Topic	PF Response
WSCC First round of questions (Additional comments received from WSCC in Red, PF responses in Blue)	
1. Design speed – This is still quoted as 30mph. However, no reference to the WSCC Speed Limit Policy is provided. As such, the applicants should set-out whether-or-not the new A29 road accords with that Policy.	The Design of the A29 is seeking to align with WSCC Speed Limit Policy, however it should be noted there are some outside influences which has impacted and shaped the design process. Further to various meetings with WSCC on the road design in 2019 and 2020 and prior to the submission of the Planning Application there was an agreement between WSCC highways team, WSCC A29 delivery team and The Southern Consortium that the A29 would be subject to a 30mph design speed. Reference to these discussions are highlighted in our Design Statement. In line with WSCC Speed limit policy the main elements are, the road will need to demonstrate that any design speed chosen is self-enforcing and this will be influenced by design speed related parameters but also by the road width, alignment and layout constraints (number and type of junctions, pedestrian crossings, frontage

Drawing Title
**INITIAL BRIDGE OPTIONS
MULTI SPAN**

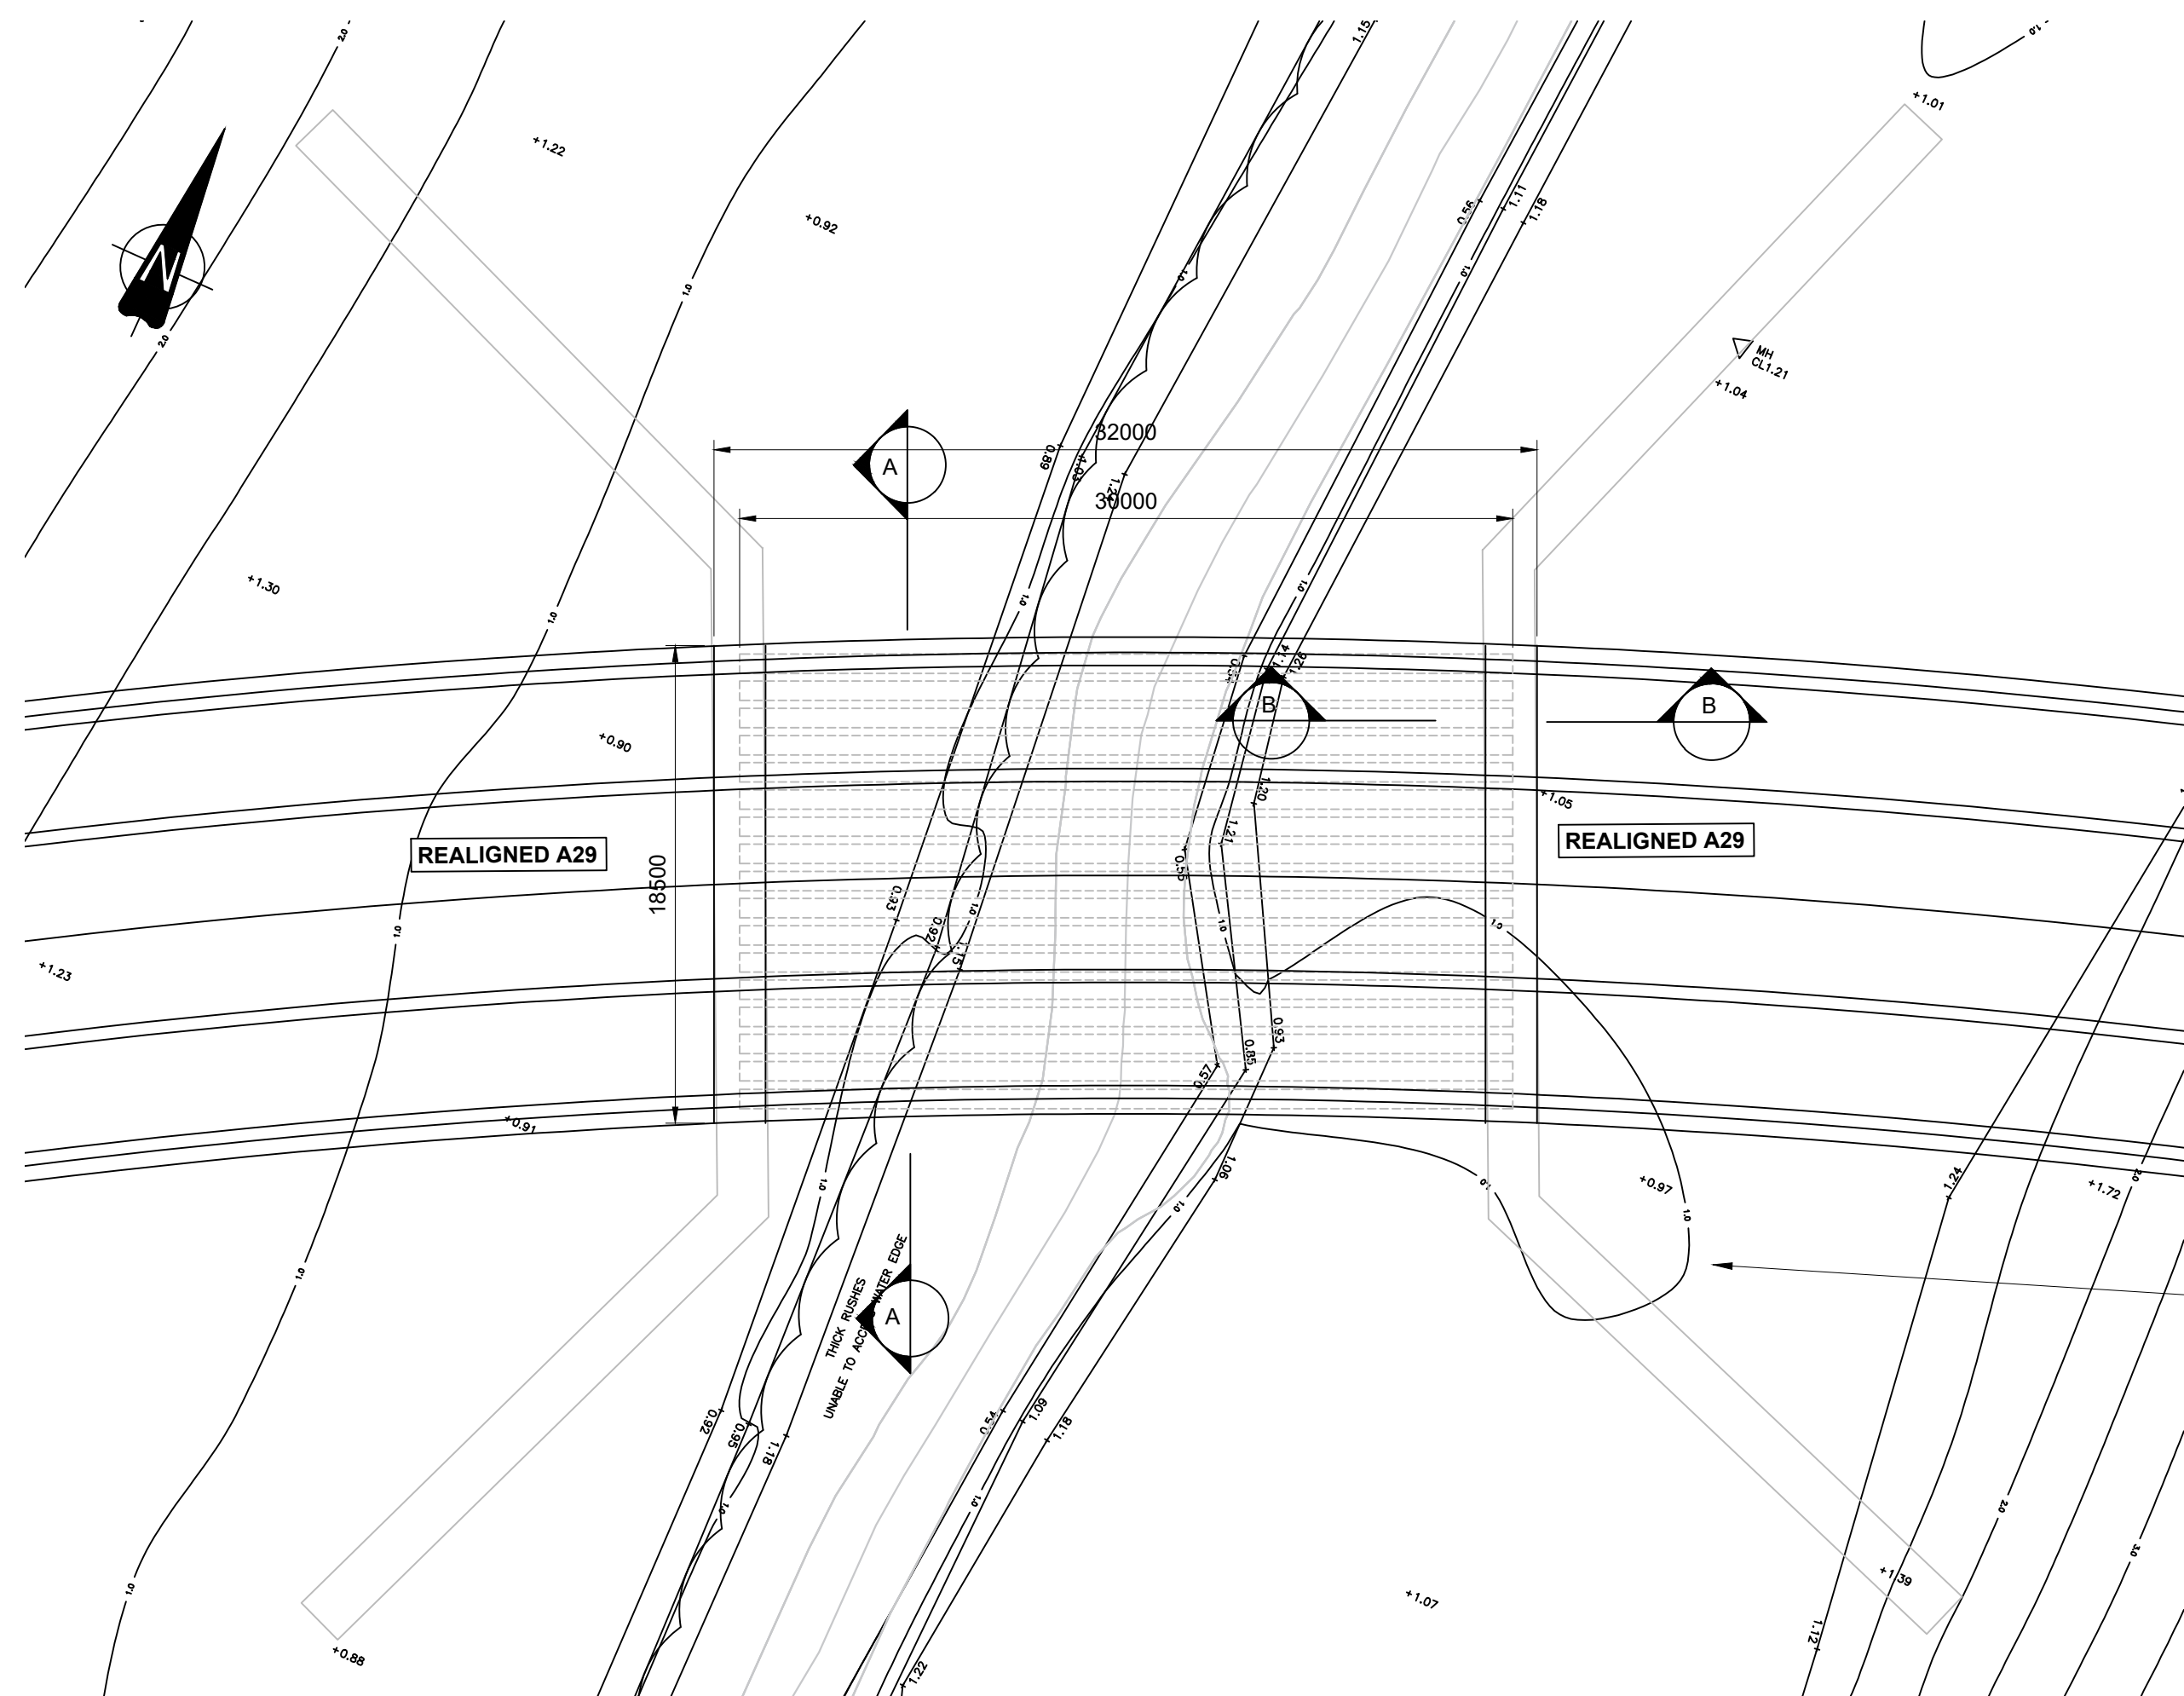
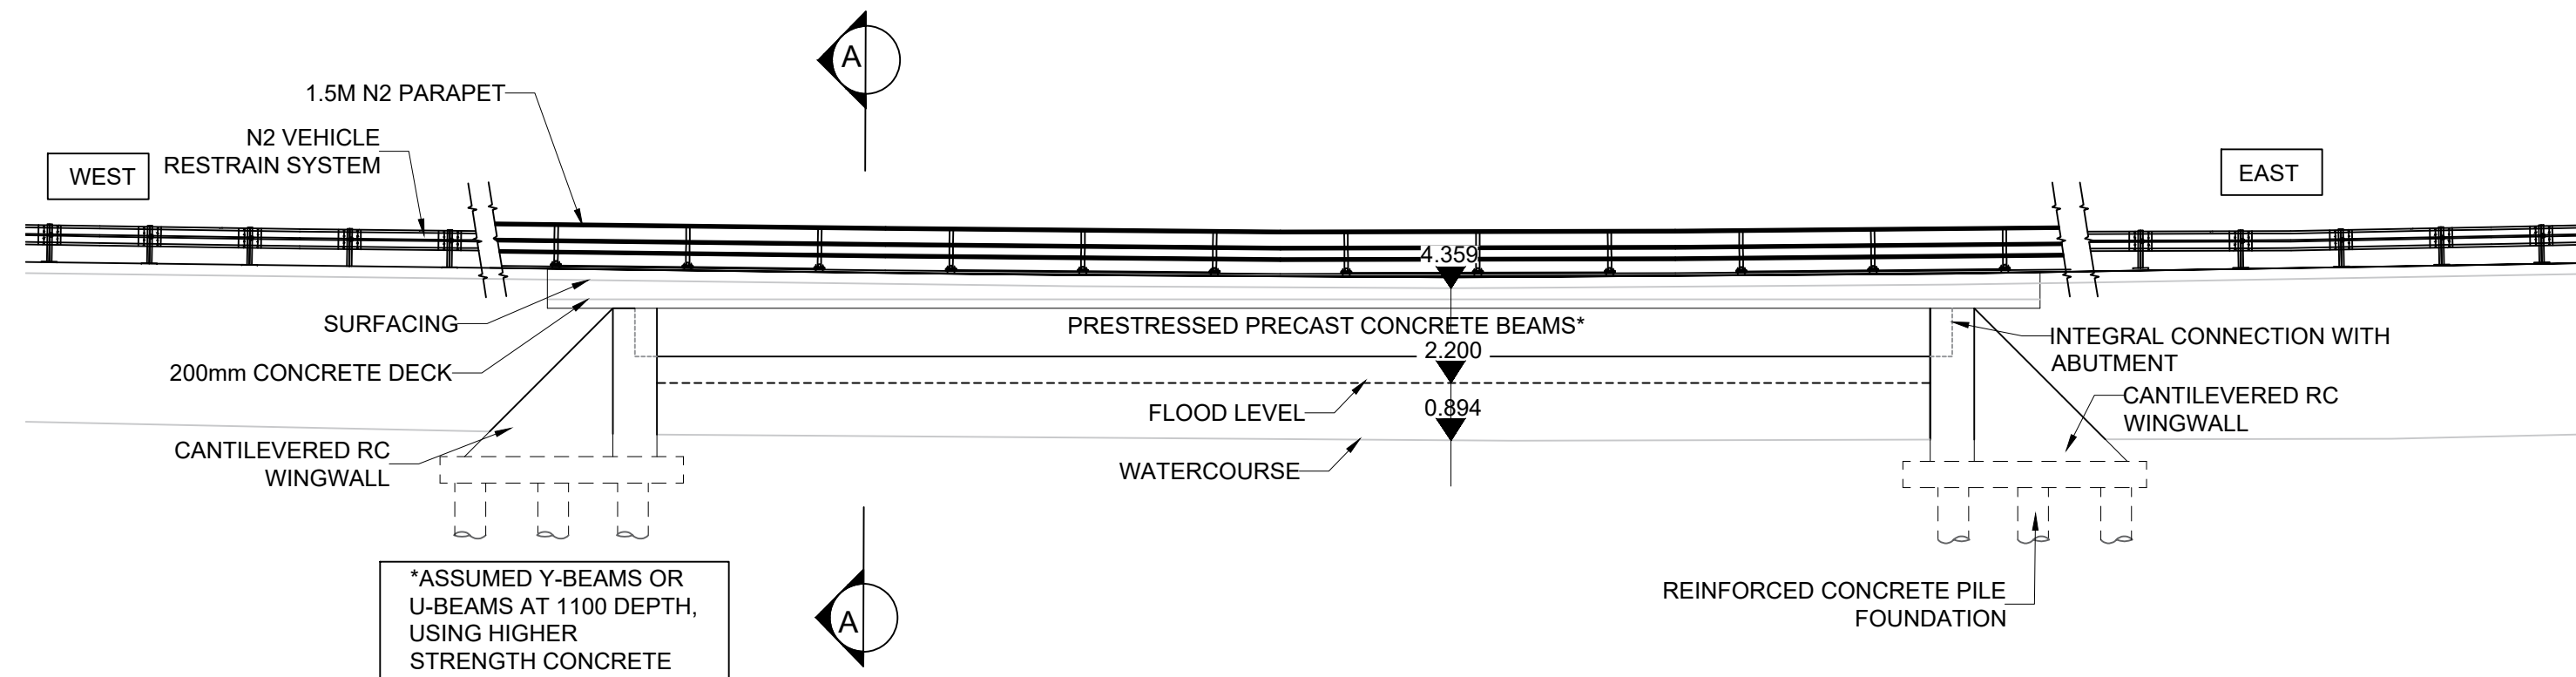
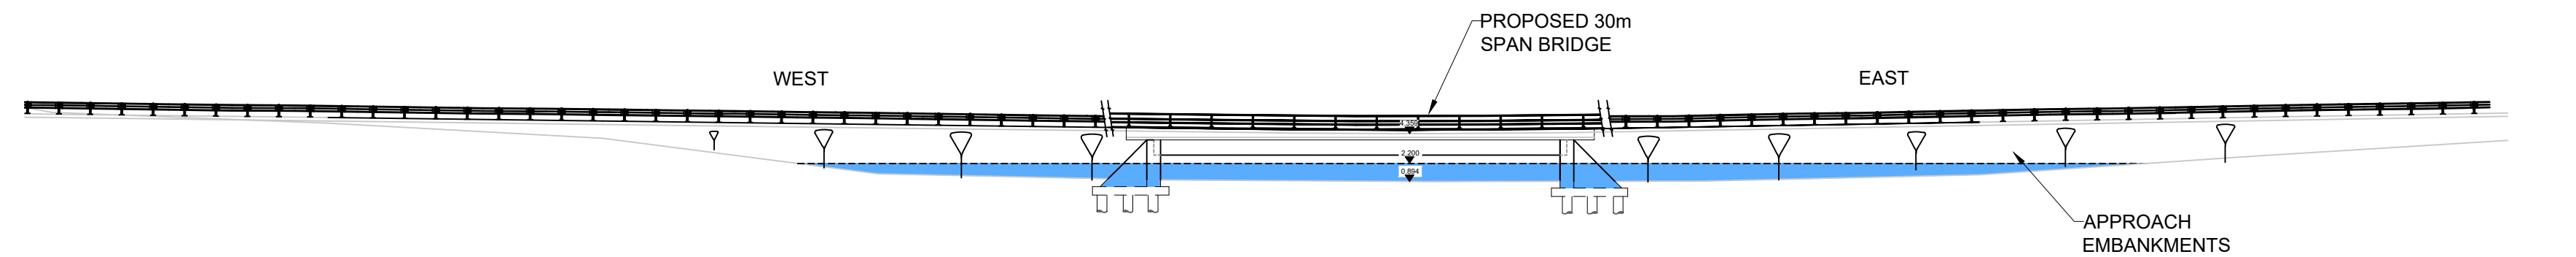
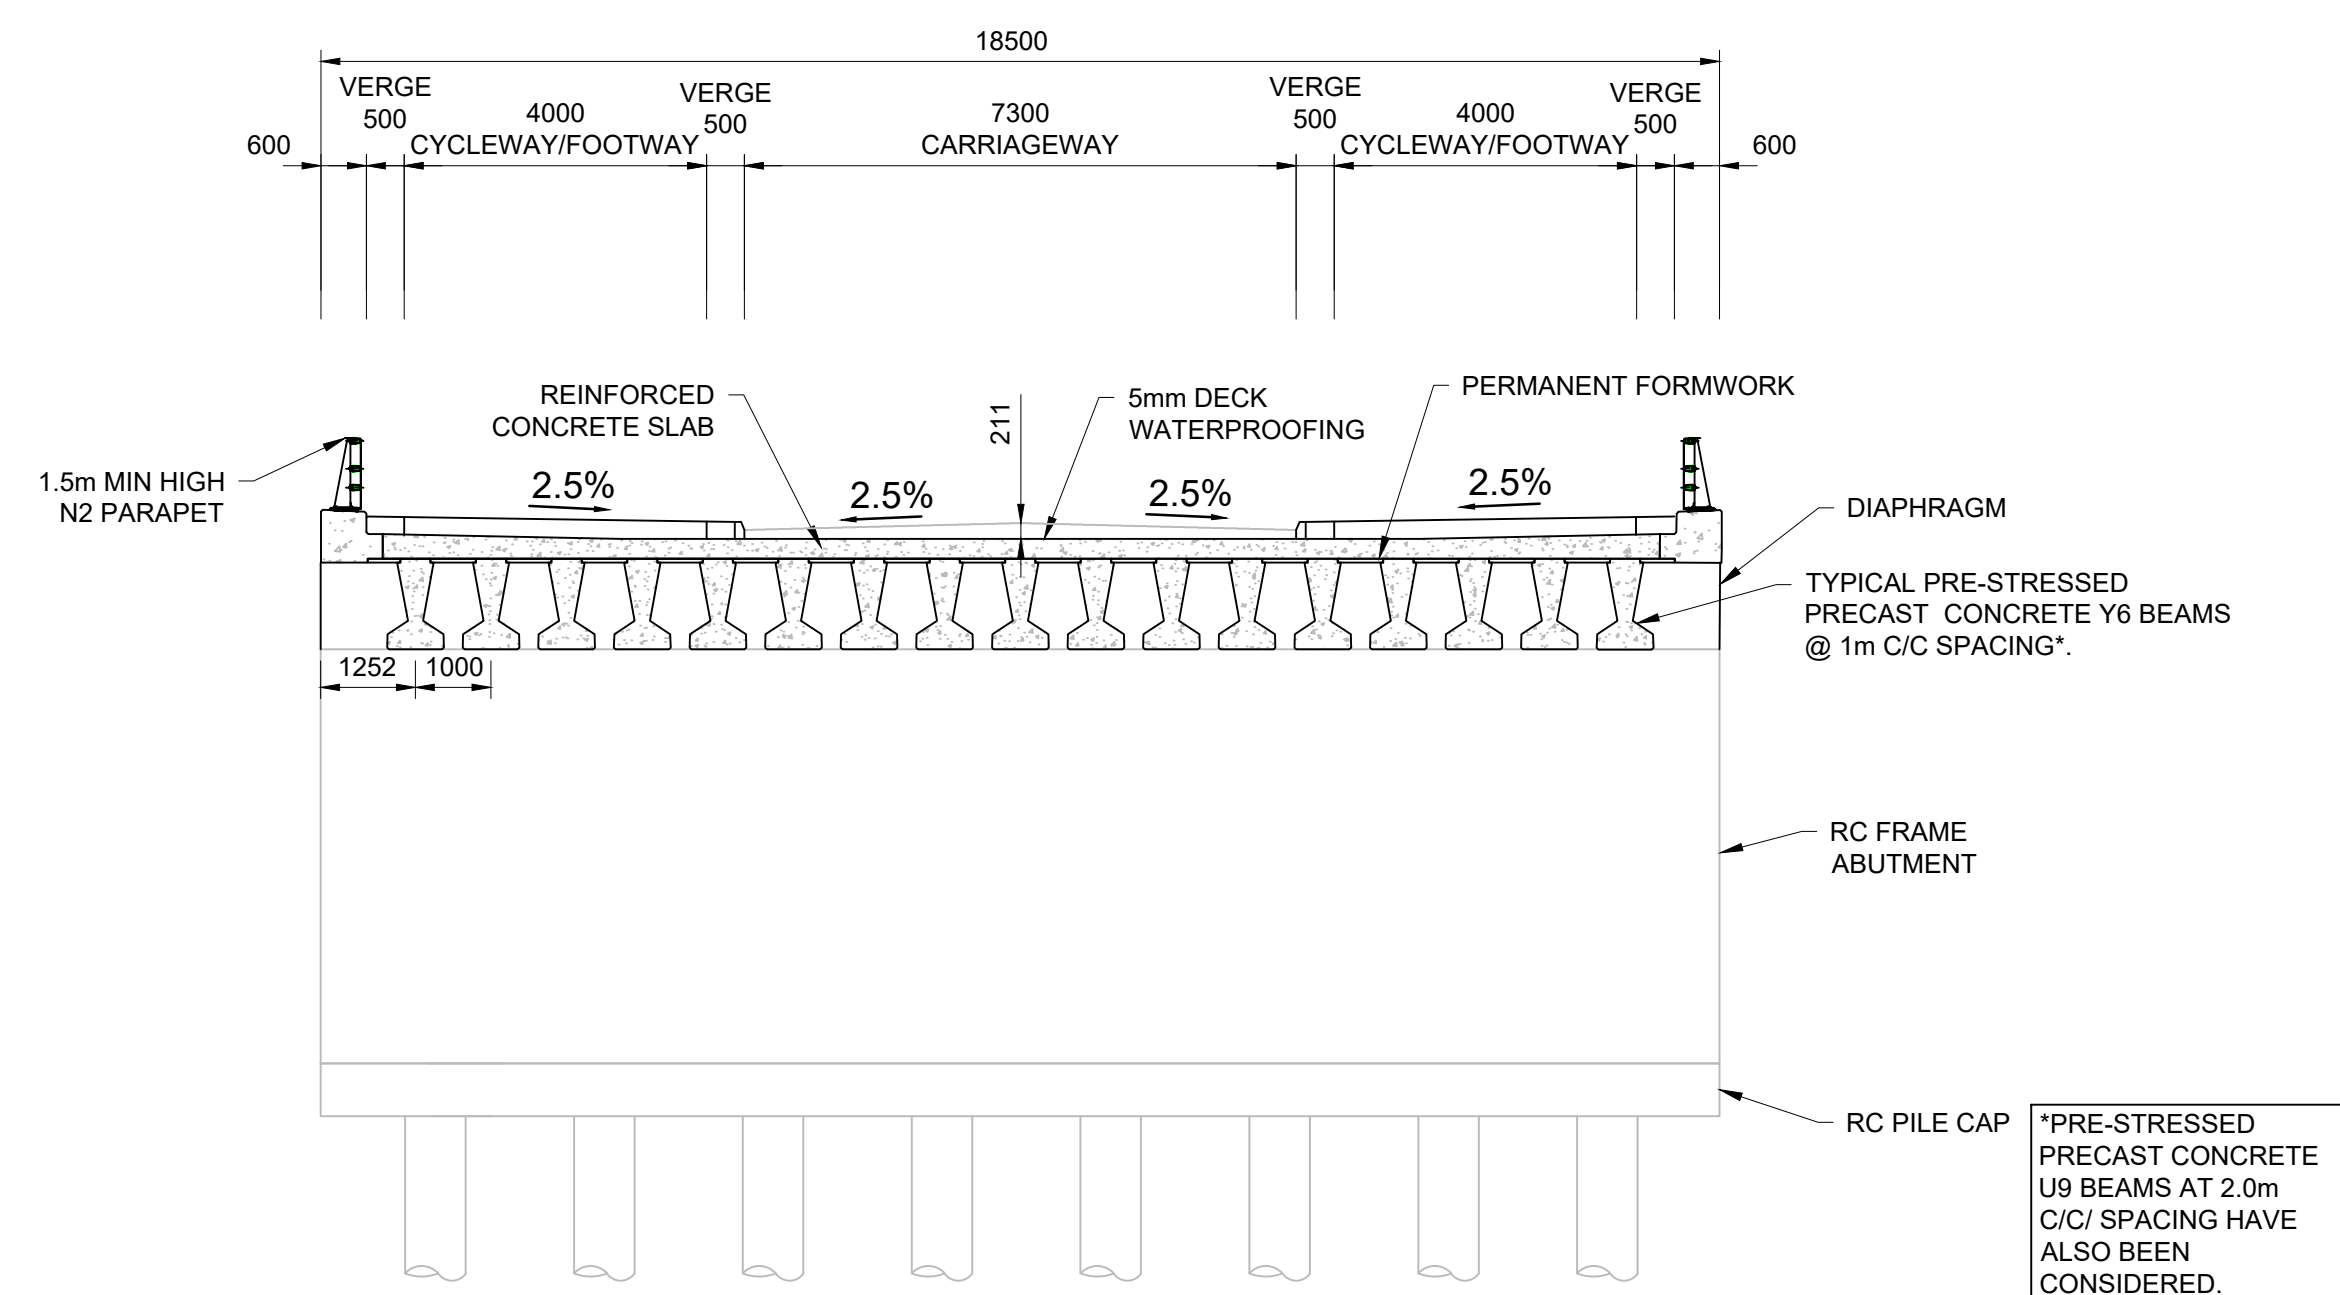
c. It is appreciated that deeper beams result in more fill on the approaches, but with Y6 beams at 1.0m centres there is not enough space between the beams to inspect the inside faces (gap is currently approx. 250mm). Deeper beams at larger centres are necessary.	Changed from Y6 to Y8 beams at 1.2m c/c. Alternatively W13 beams at 3.25m c/c are included in the technical note.

d. The cantilevers look too wide given how thin the deck slab is(?).	Cantilever reduced due to new Y beams and changes to the highway section.
e. Typically with a Y beam deck there are YE beams.	YE beams added.

g. The report touches on the lack of clashing with existing services, but what about new services? There is not a lot of fill to accommodate larger diameter mains. It is appreciated that this is the first submission but WSCC would like to see something on the drawing that is indicative and calls up that the utilities are TBC.	Drawing updated to indicatively show new services within the footways of the bridge. Specific requirements to be confirmed during consultation/enquiries with Statutory Authorities (Utilities).
